Doc no. DOC19/593791
File no. SF19/76662

**RE: Response to Response to Submissions (RTS) of Sydney Opera House (SOH)
Building Renewal Program – Concert Hall Upgrade and new Creative Learning Centre
(SSD 8663)**

ATTACHMENT A: SYDNEY OPERA HOUSE BUILDING RENEWAL PROGRAM
CONCERT HALL & CREATIVE LEARNING CENTRE HERITAGE RESPONSE TO
SUBMISSIONS RESPONSE

LEVEL 2A
CRANK POINTS HIGHLIGHTED

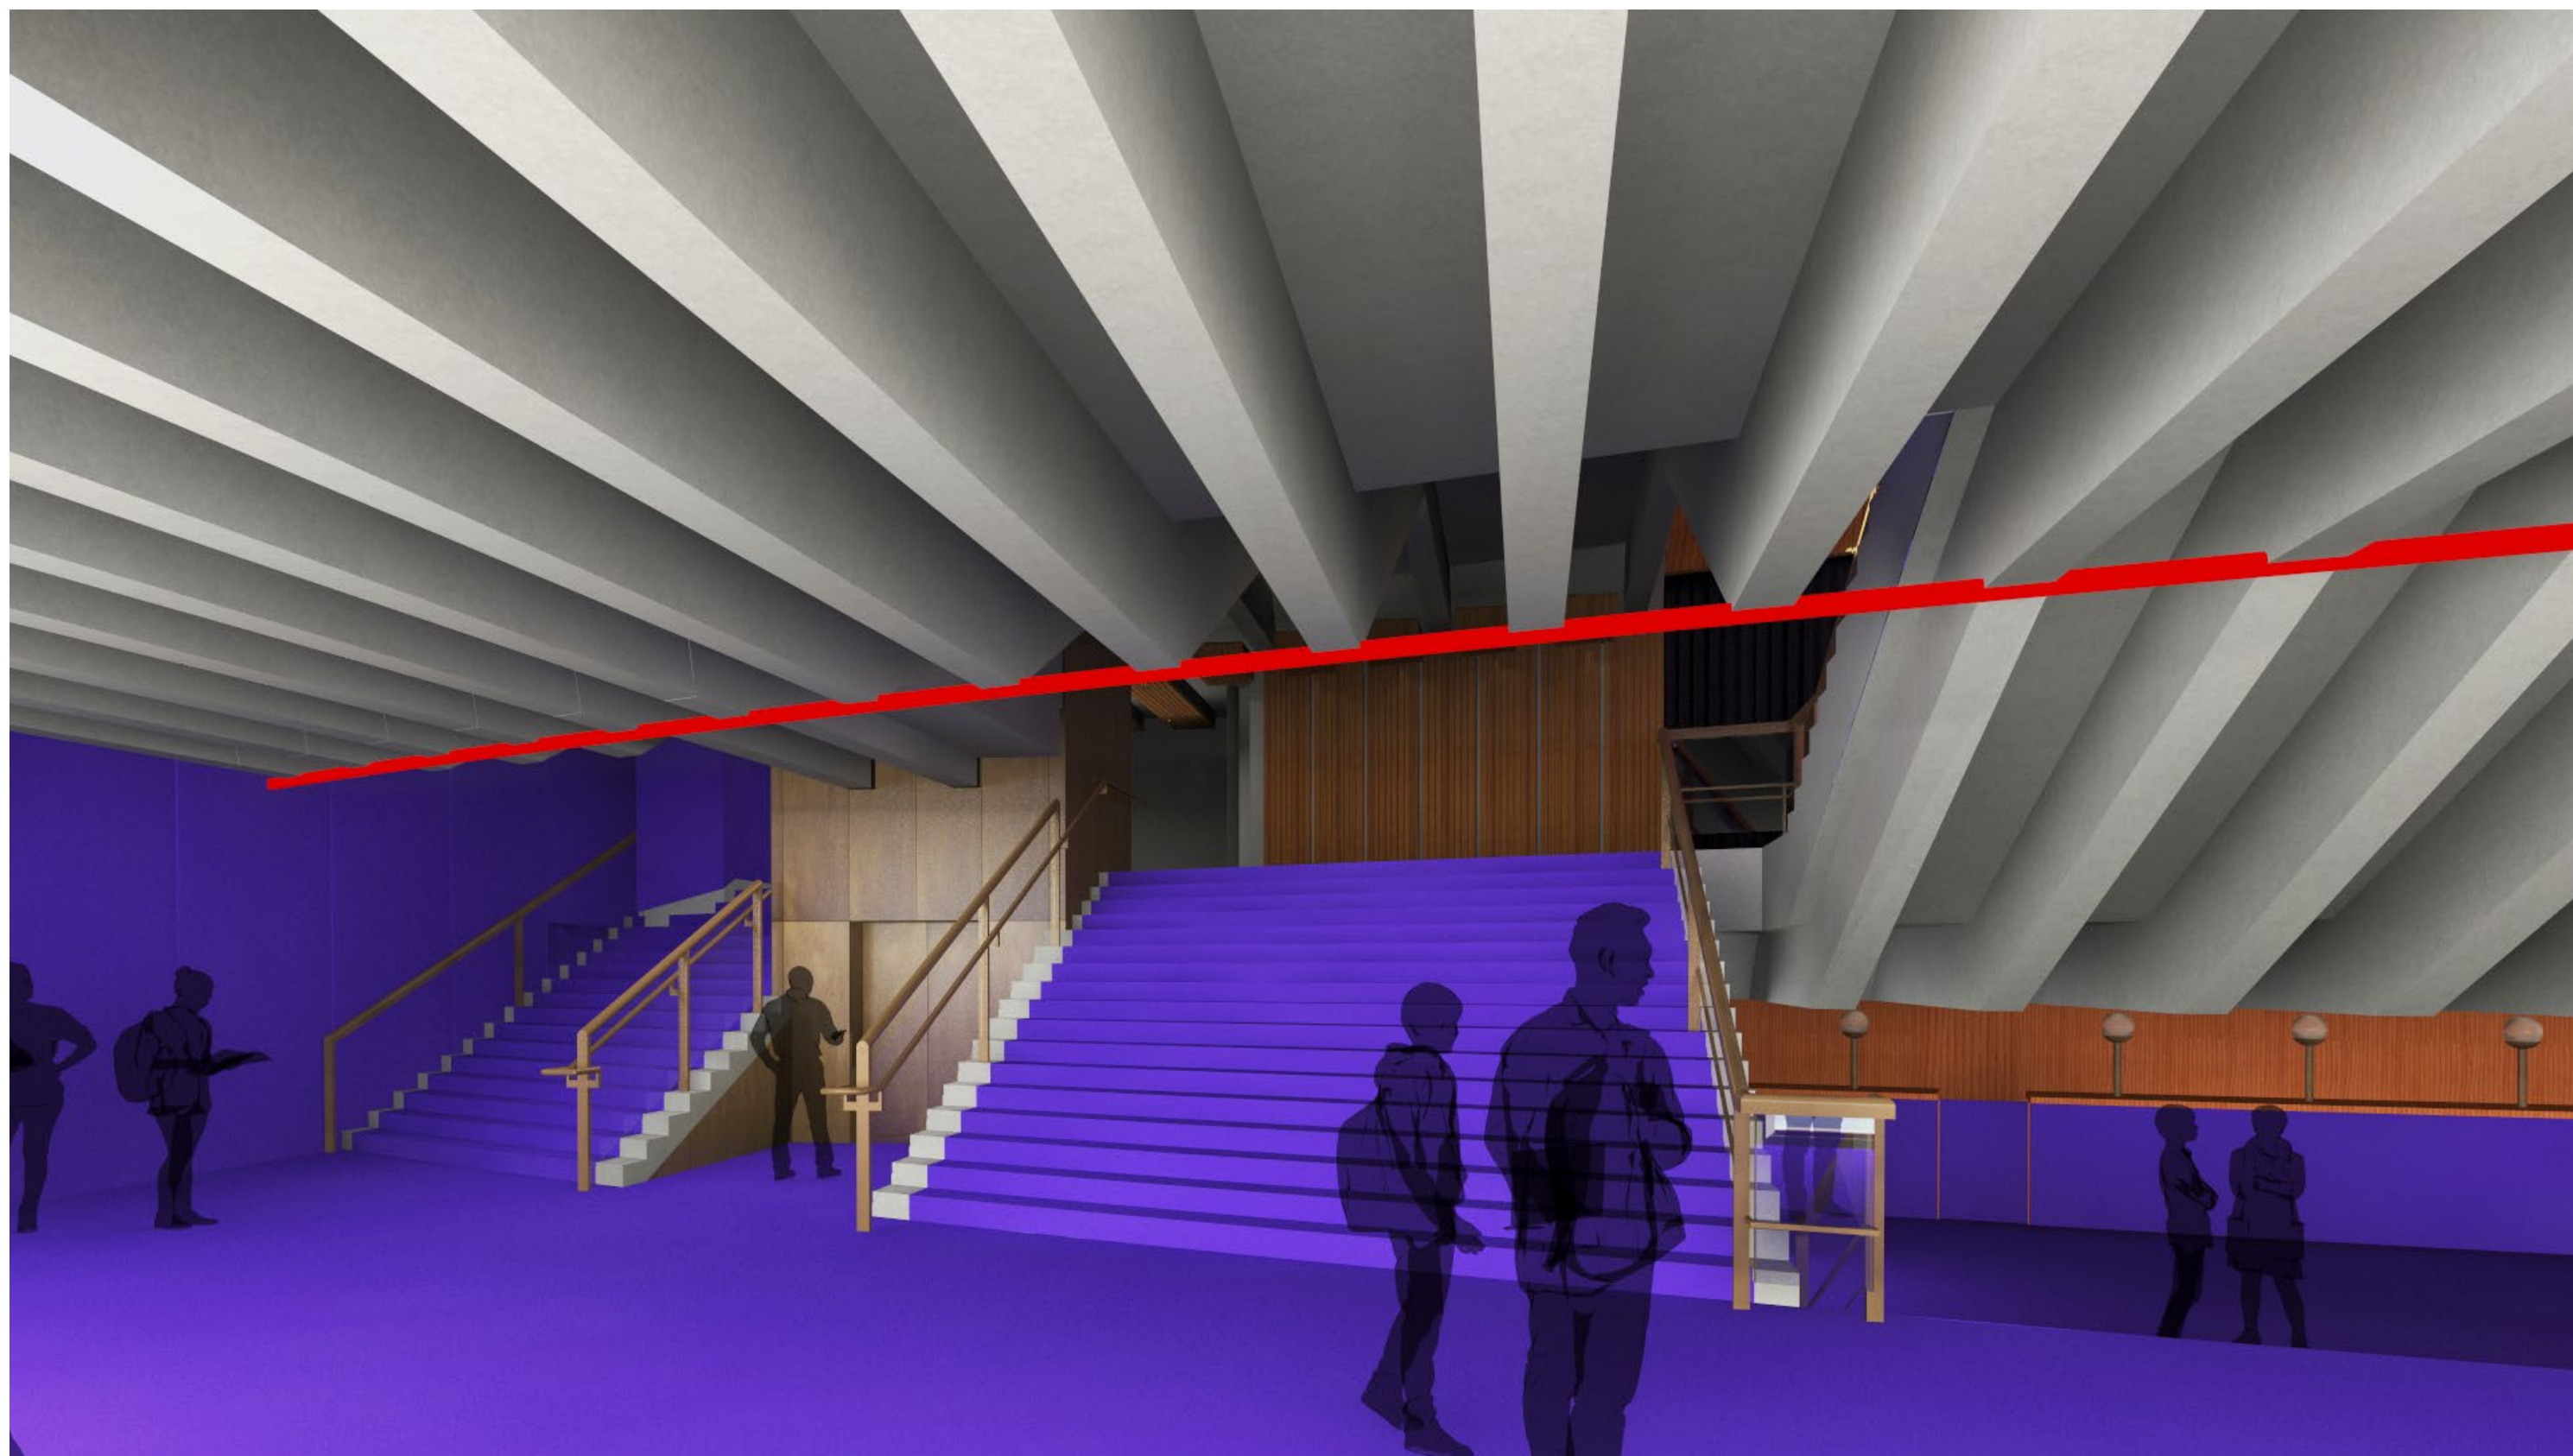
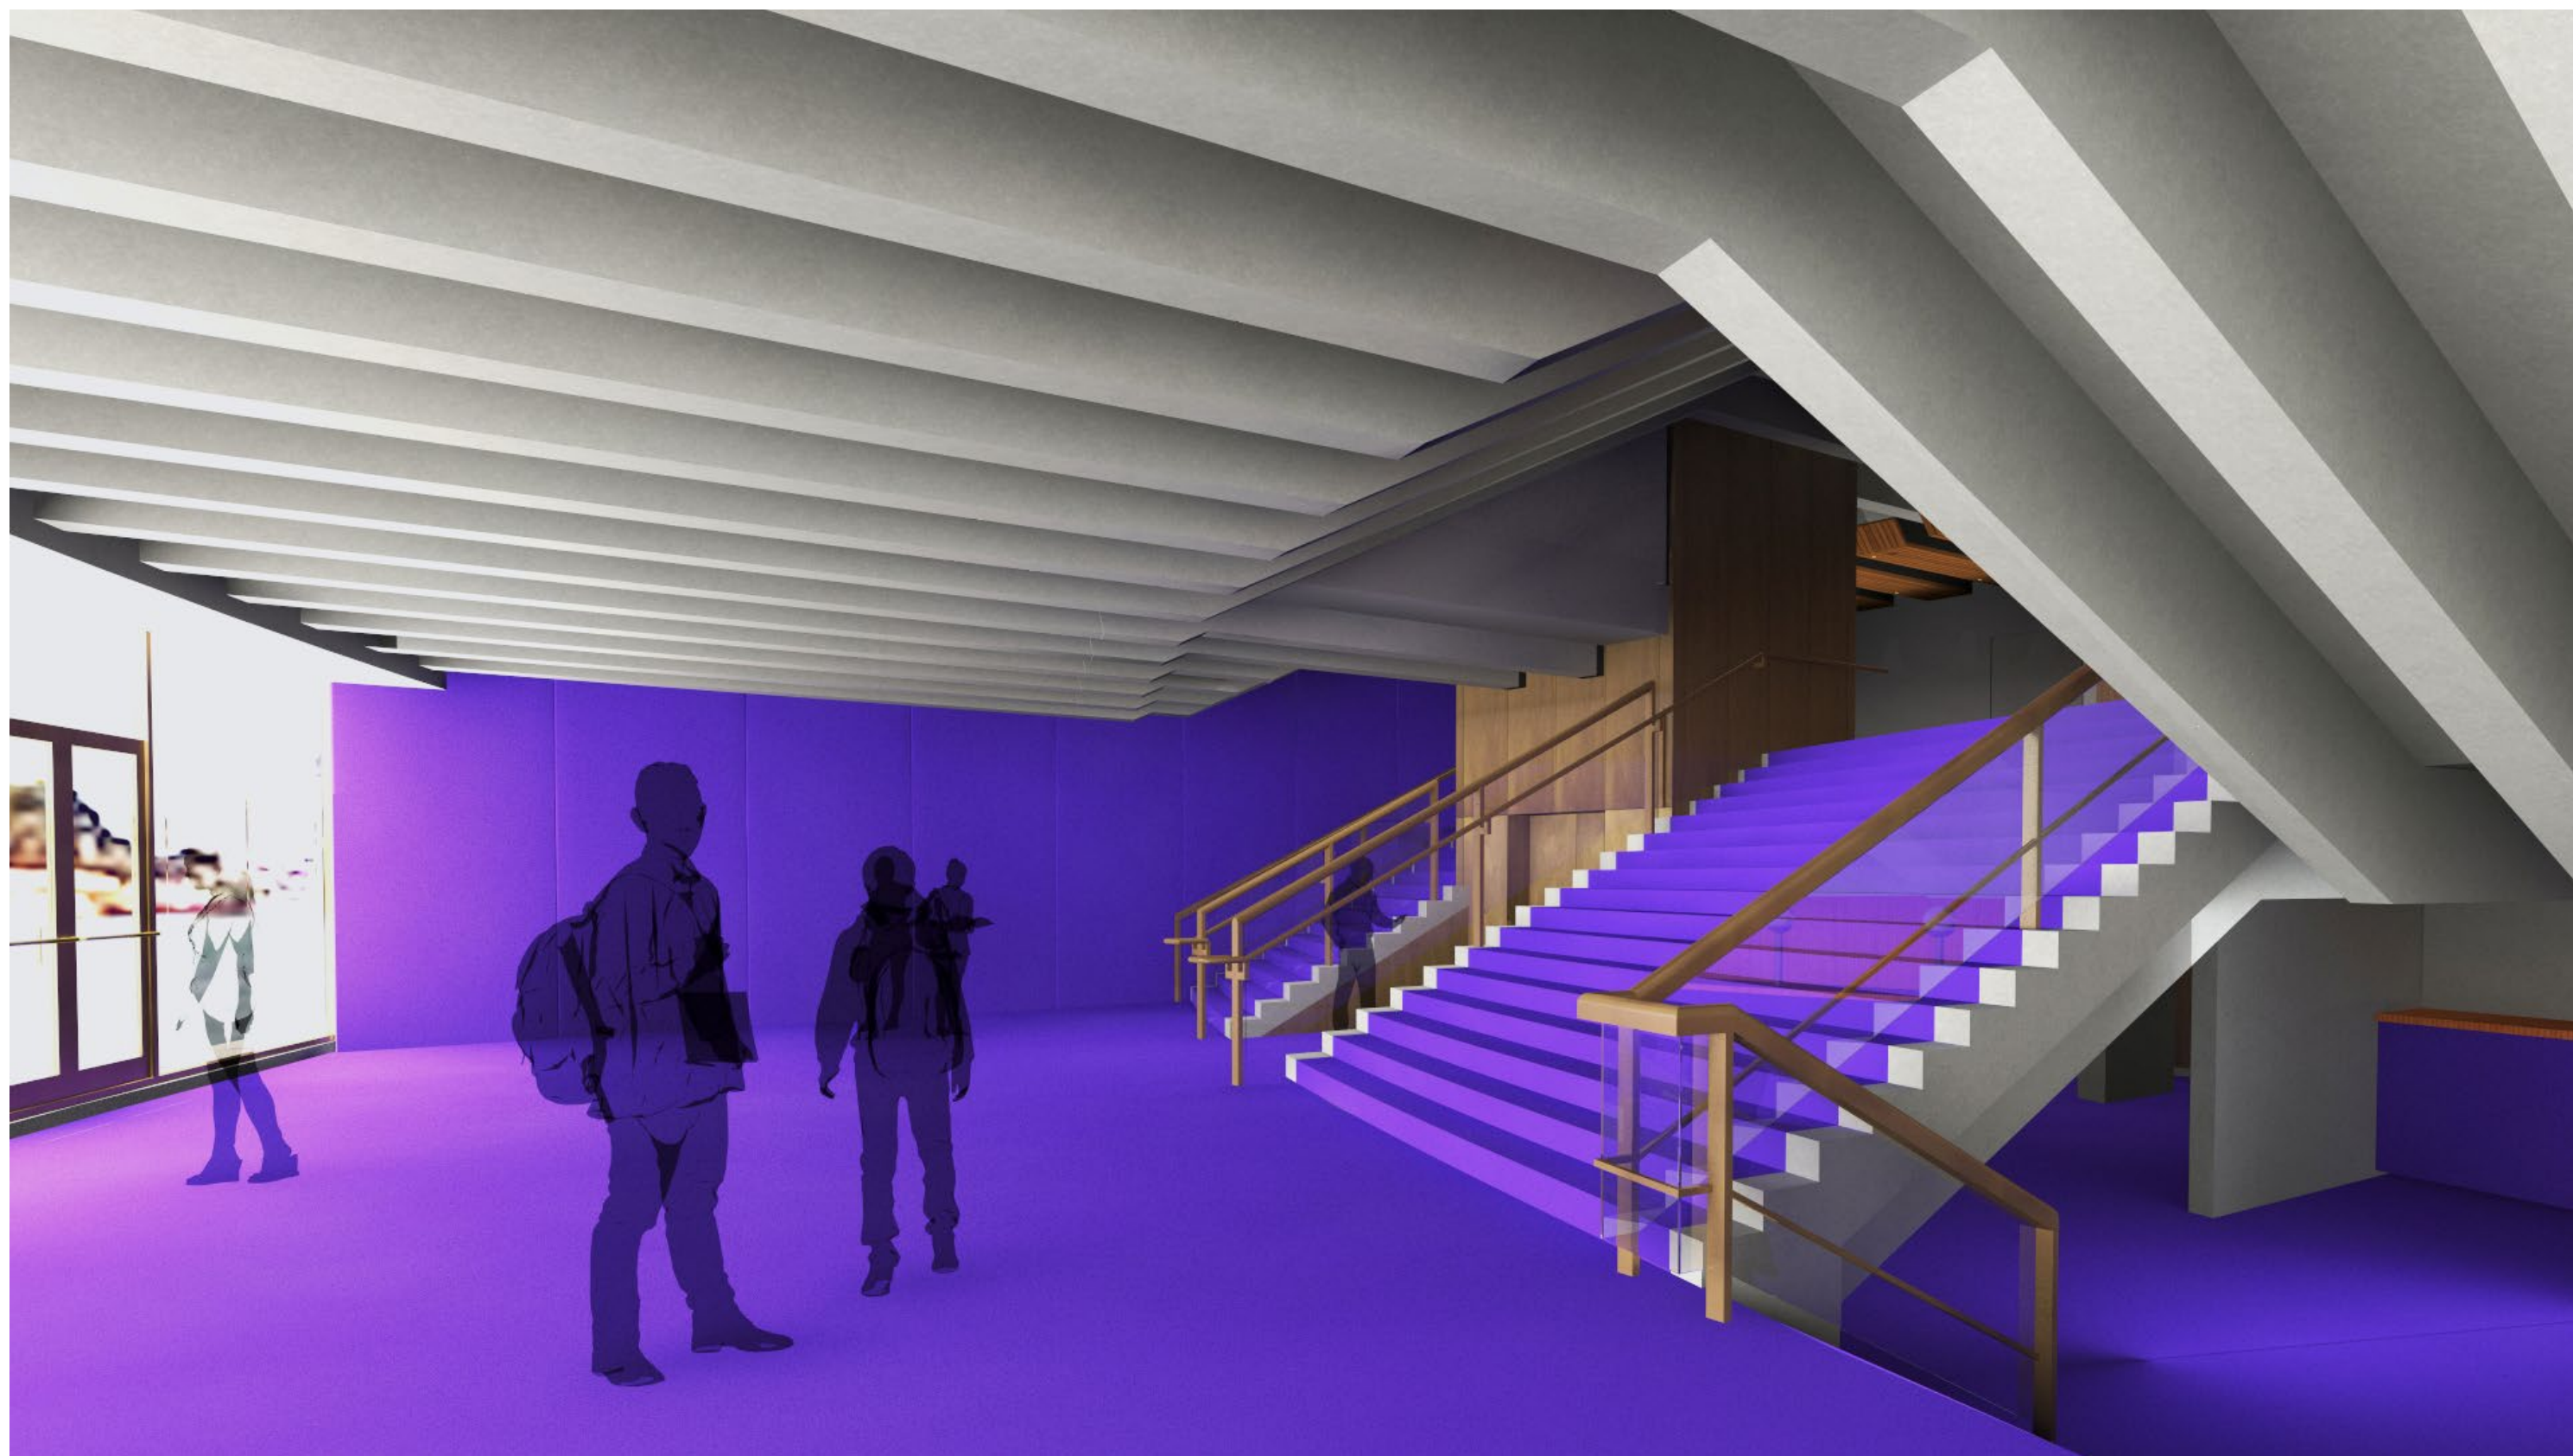
- 2.23 It is still considered that the proposed detail to extend two beams to the new lift adversely impacts the aesthetics of the distinctive bend line of the cranked beams. The design of this detail requires further refinement to better integrate the beams within the existing significant design aesthetic and minimise visual impacts.

- 2.24 The proposed detail of the extension of two cranked beams connecting to the new lift should be reviewed and revised to minimise visual impacts and to ensure the new works do not disrupt the aesthetic qualities of the distinctive line of crank points in the beams.
